1 FIRST FLOOR PLAN
SCALE: 1/8" = 1'-0"

<p>6 City Center Exterior Renovations</p> <p>6 City Center Portland, ME 04101</p>		<p>Michael Charek Architects</p> <p>25 Hartley Street Portland, Maine 04103 (207) 761-0556</p>
--	--	---

<p>Title</p> <p>FIRST FLOOR PLAN</p> <p>REV. 9/15/16: H.C. TOILET ROOM DETAILS</p> <p>Scale: 1/8" = 1'-0"</p> <p>Date: 9/15/16</p> <p>Sheet</p>	<p>A1.2</p>
---	-------------

Sheet
A1.2

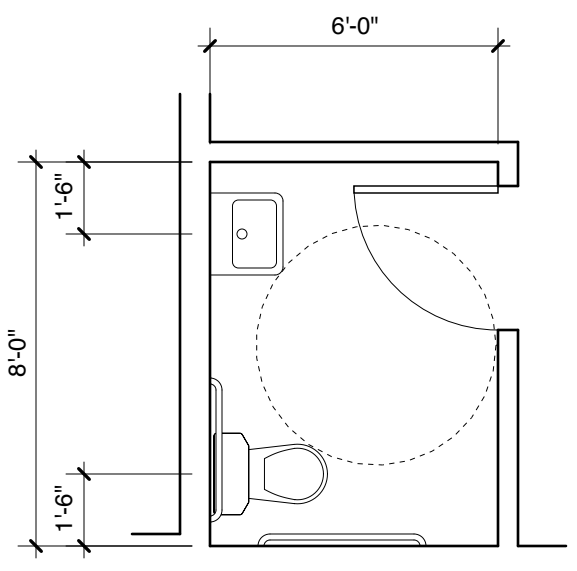
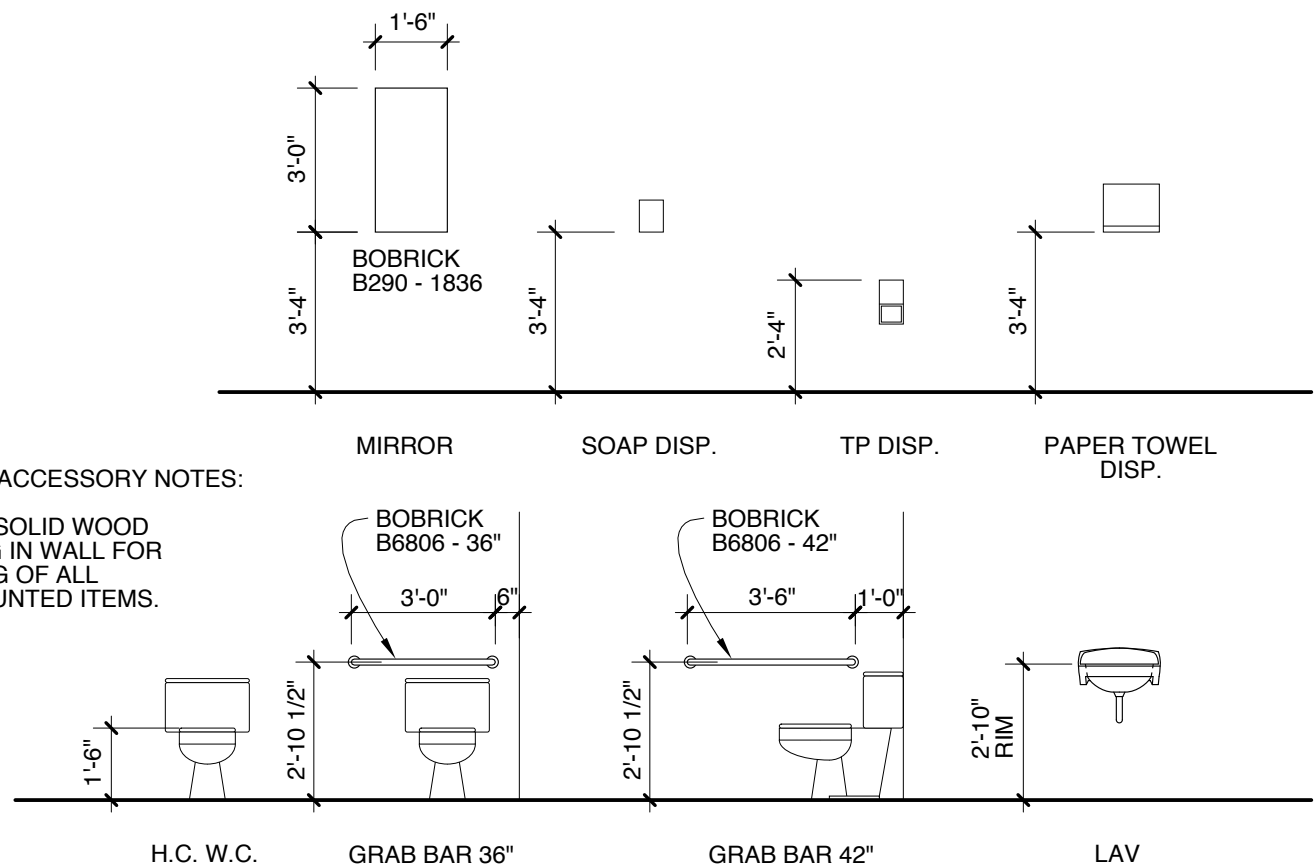
Is Permit Application 2018-00075 for more than tenant fit up of rail cabin? If not, please revise this note and the dashed line on floor plan.

Please show fire rating of partitions and UL listing number.

Does the existing building have a sprinkler system?
